DRB CASE ACTION LOG (PREL/FINAL)

Project # 1005410

Project Name: RICHFIELD PARK

RE: Lots 4 & 5, Richfield Park Subdvision

Alameda Boulevard NE
 (124' right-of-way)

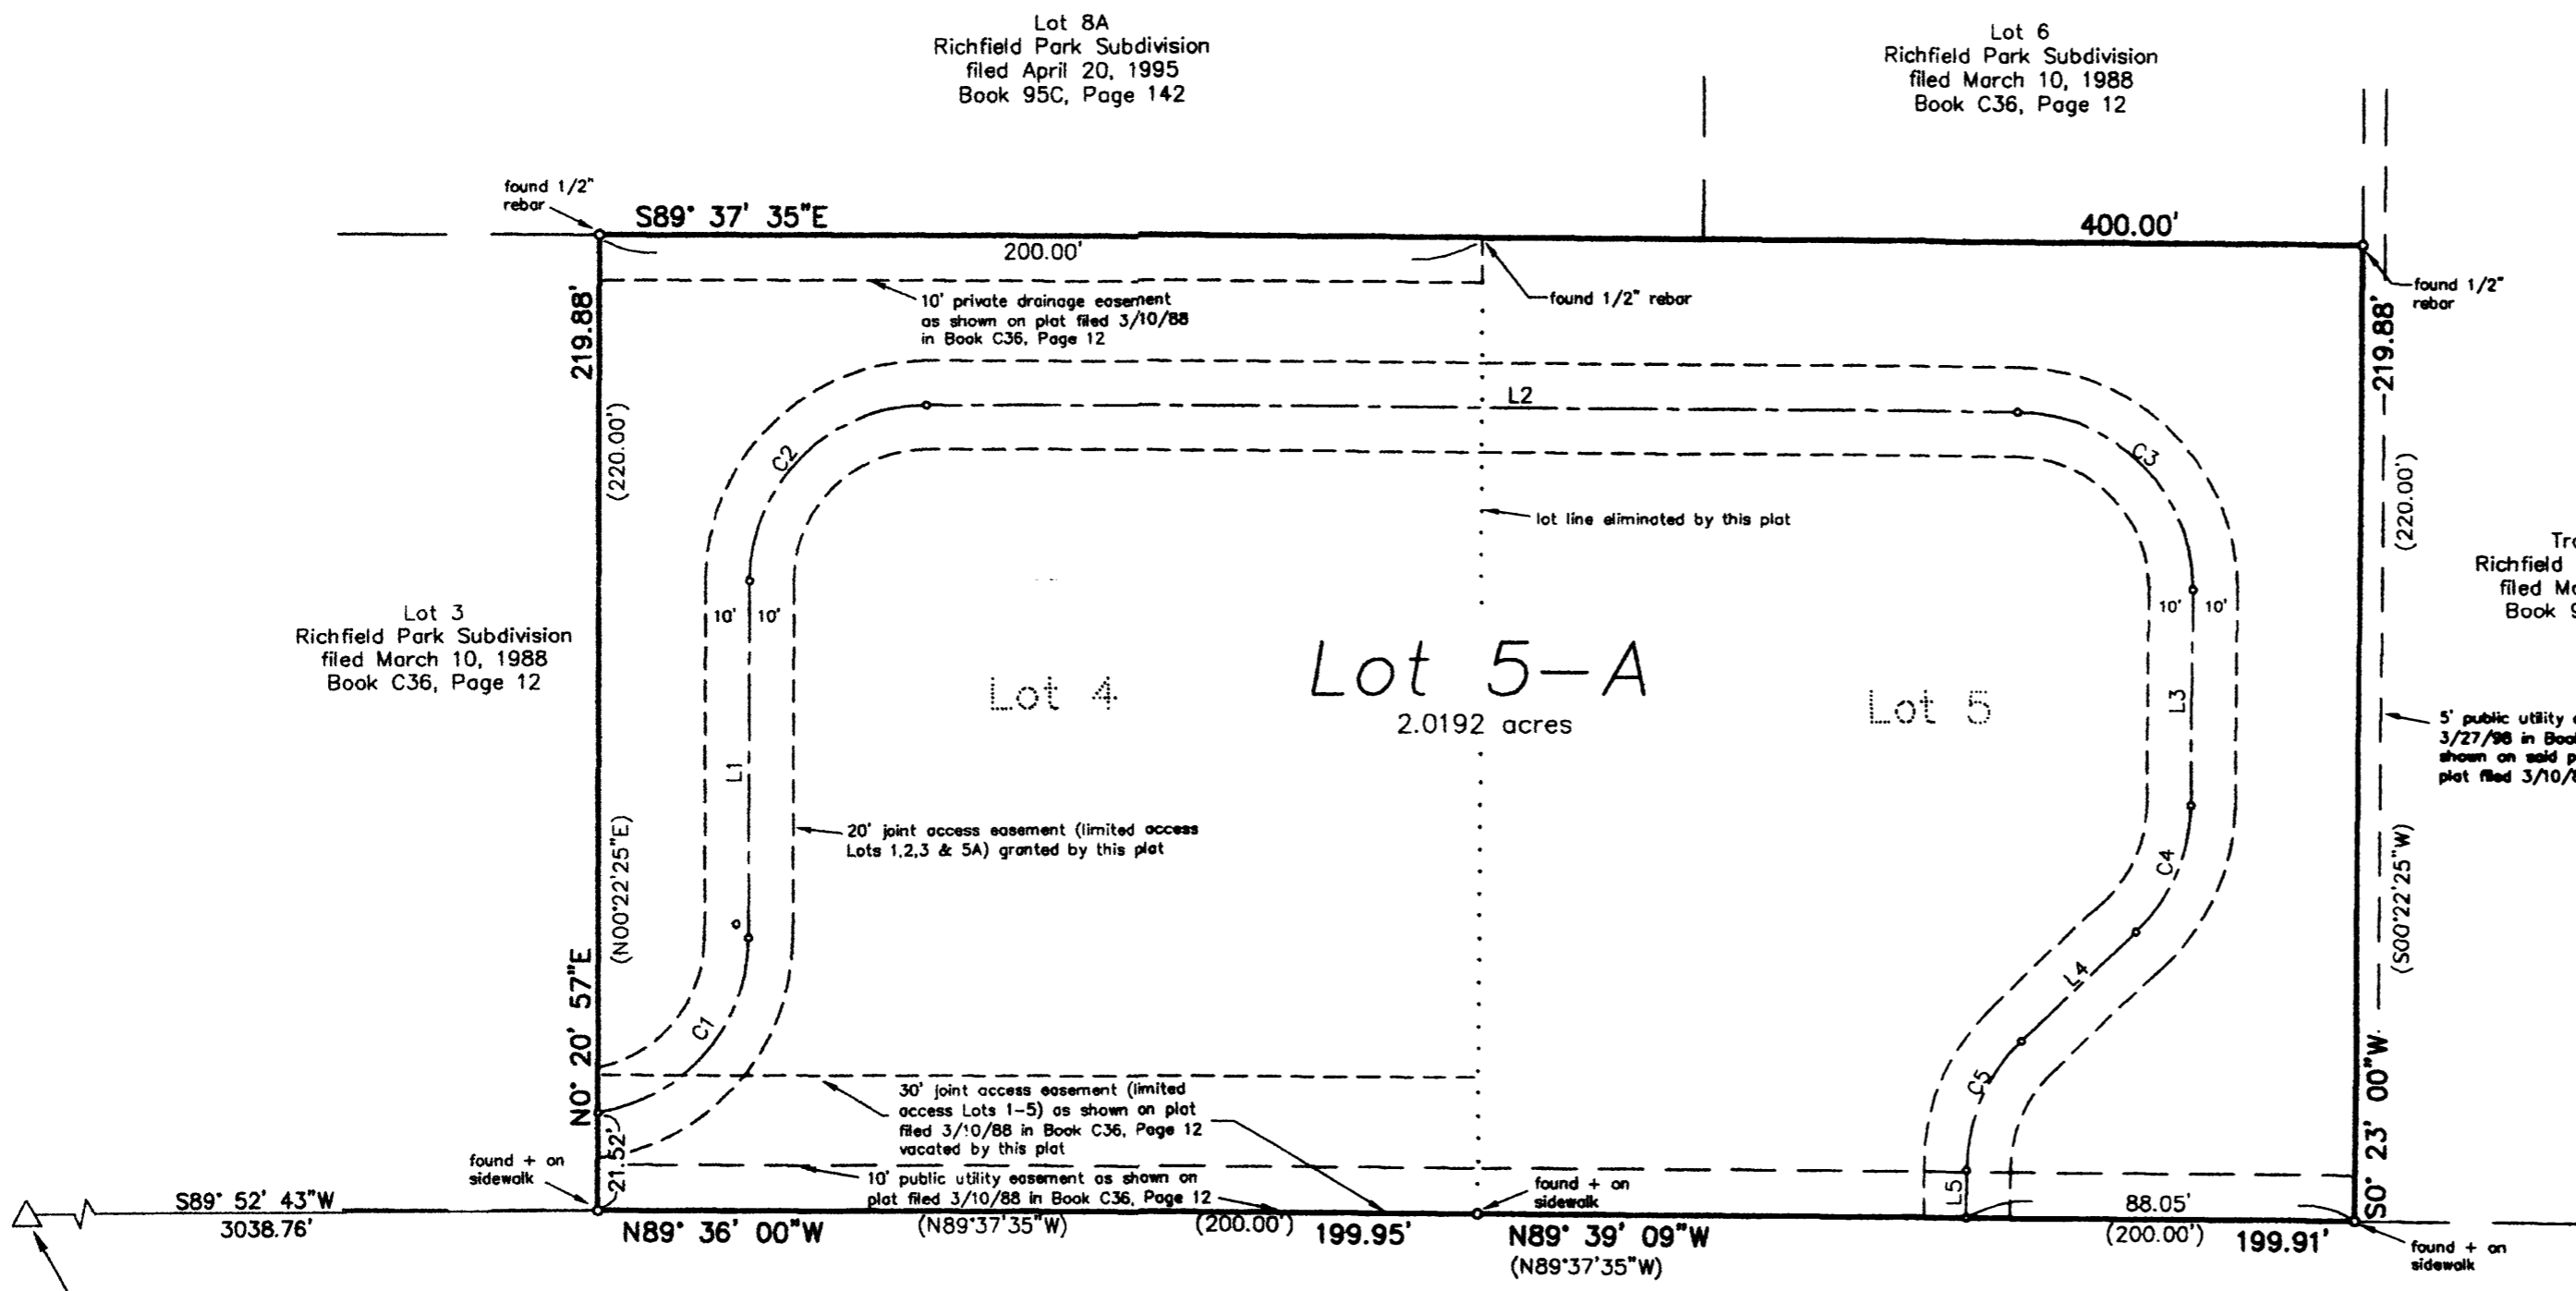
The new easement does not appear to align with the site development plan or the median break in Alameda – it needs to be shifted approximately 50 feet west (centerline to be where the western edge is now).

PRELIMINARY SET

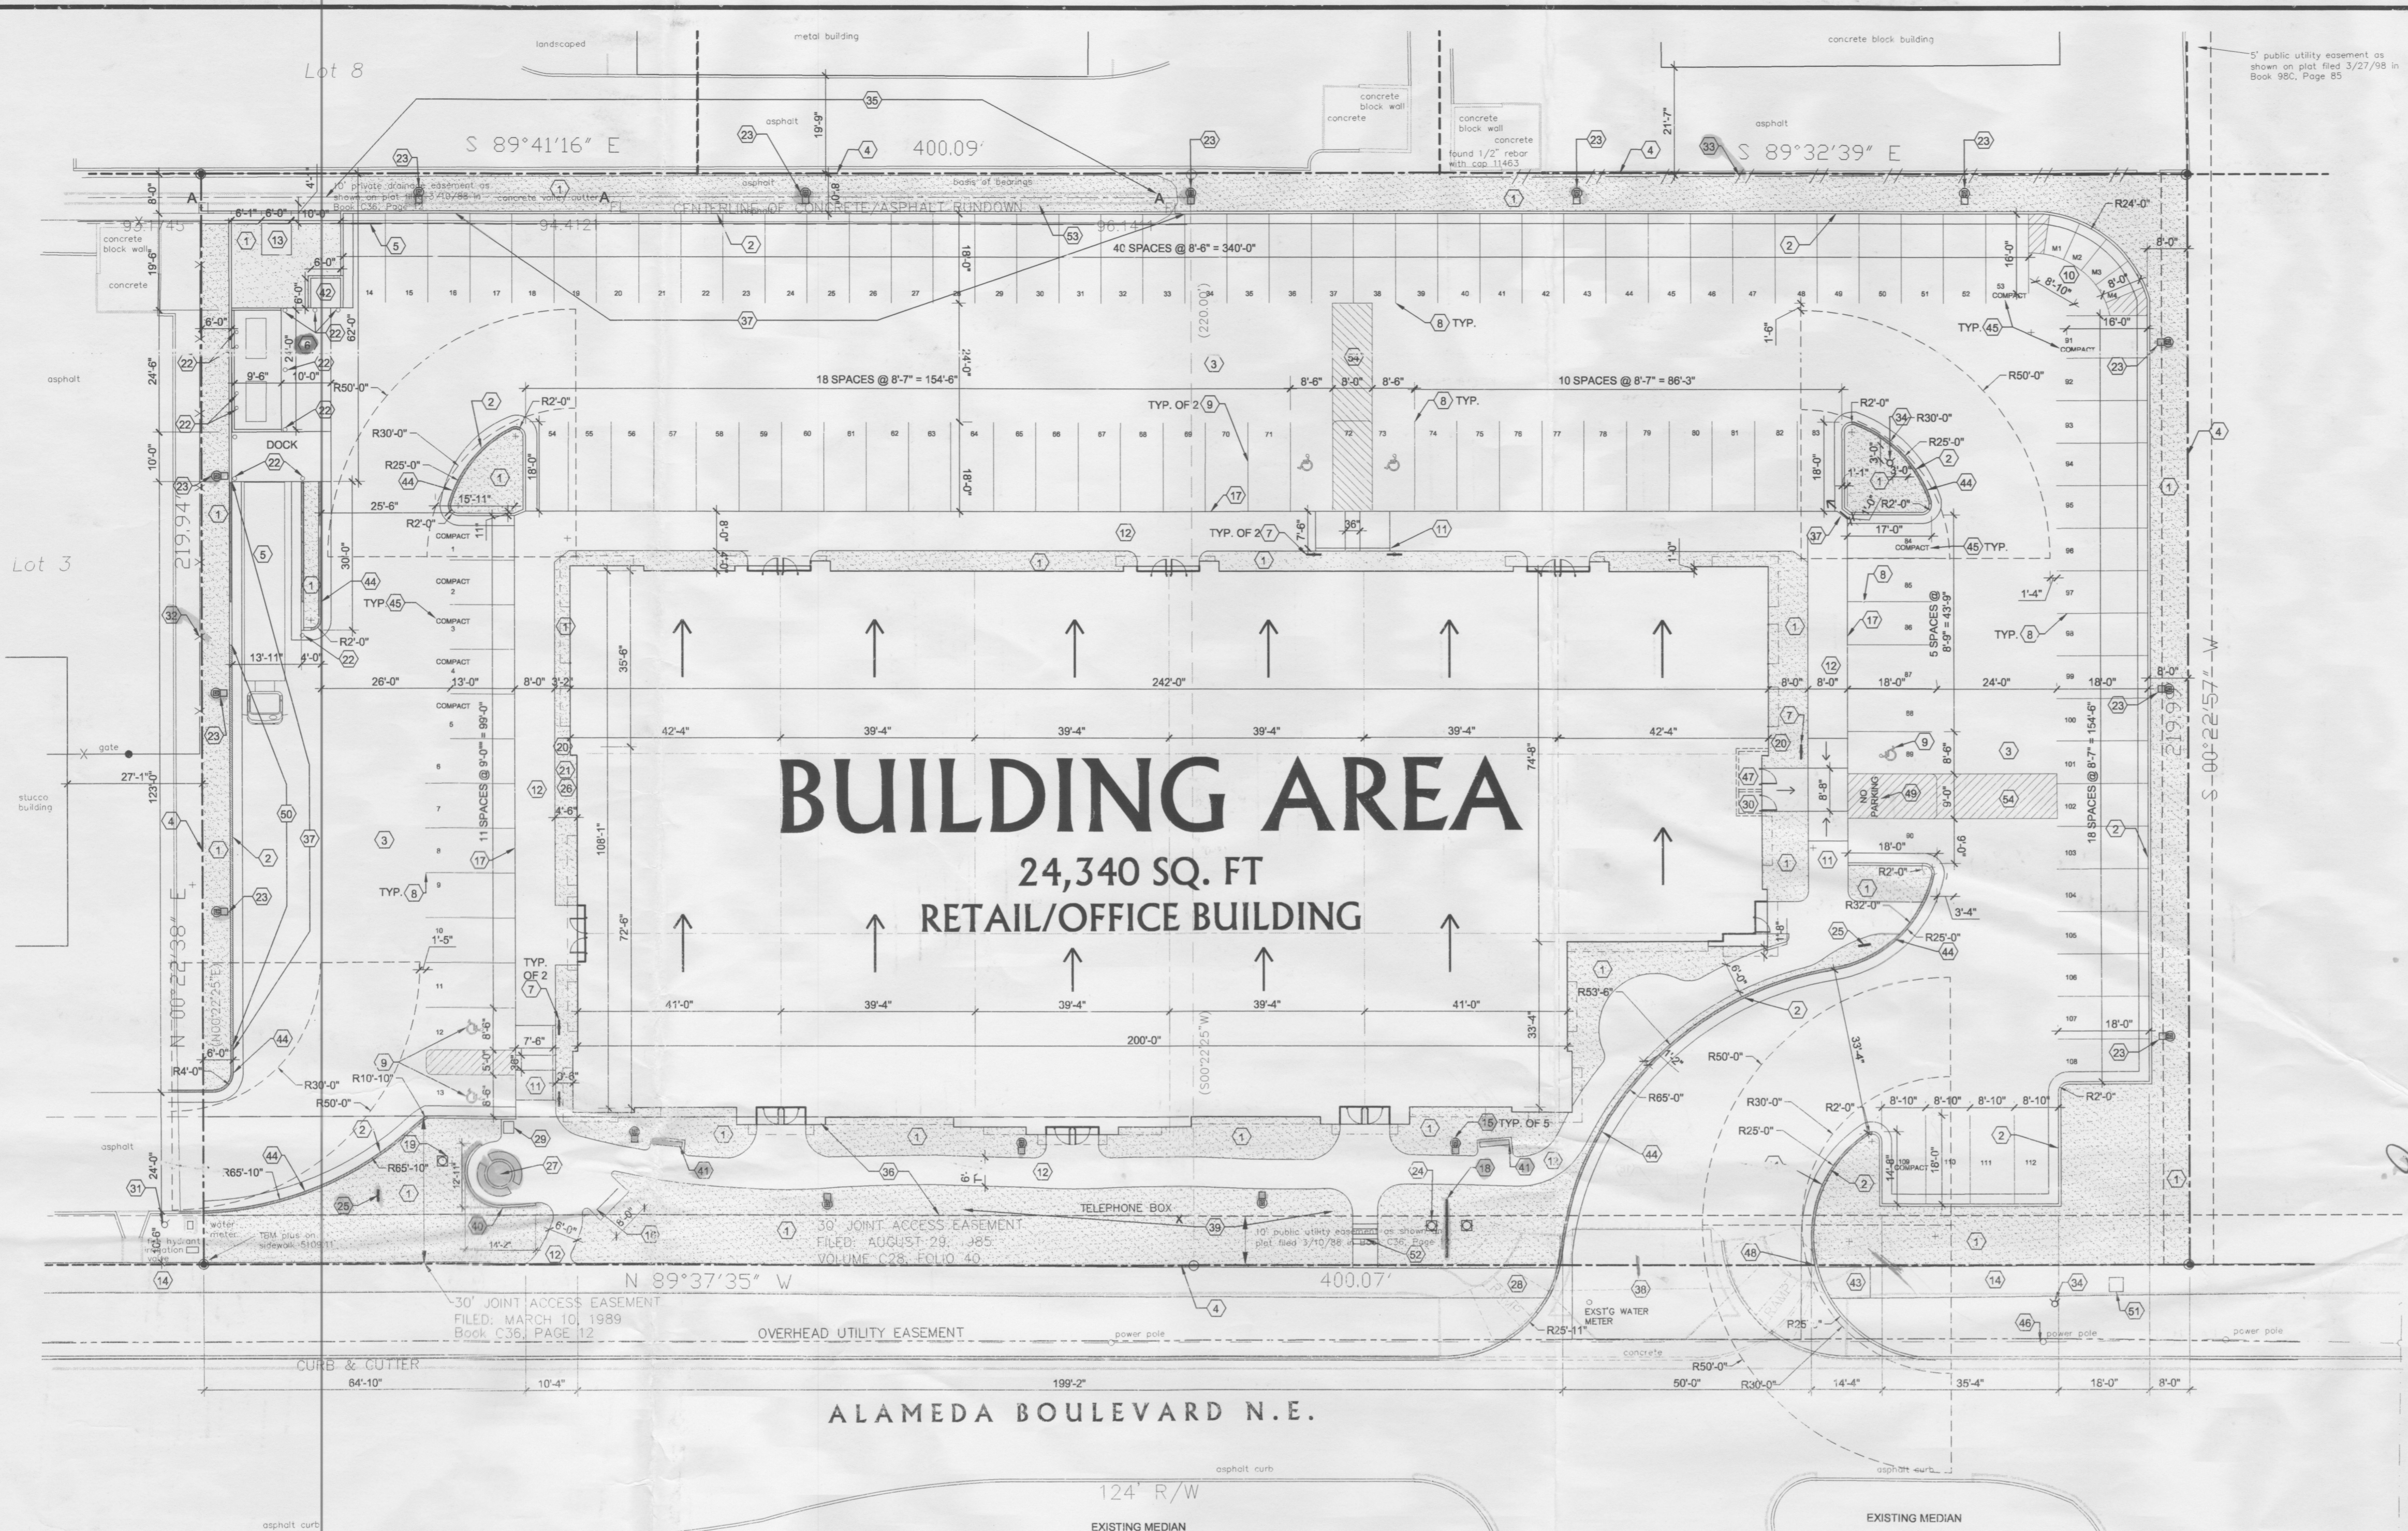
There is about 20 feet from the property line to the right of way line, none of which shows landscaping.

✓ 2. Page 27, (E)(2). The building must be separated from off-street parking areas with landscaping and 6 foot wide sidewalks. The sidewalk around the building must be 6 feet. This should be indicated in Note 12 on the site plan sheet.

→ 5. Page 27, (E)(4). All off street parking areas must be screened from all rights of way including Alameda by low walls of a continuous dense hedge. Apache plume does not make a dense hedge. The hedge should be 4 feet high. The red yuccas are too transparent.

→ The required 30 foot front yard setback must be met. A variance application is possible if the building encroaches on the 30 feet and a correction to the plan can't occur.
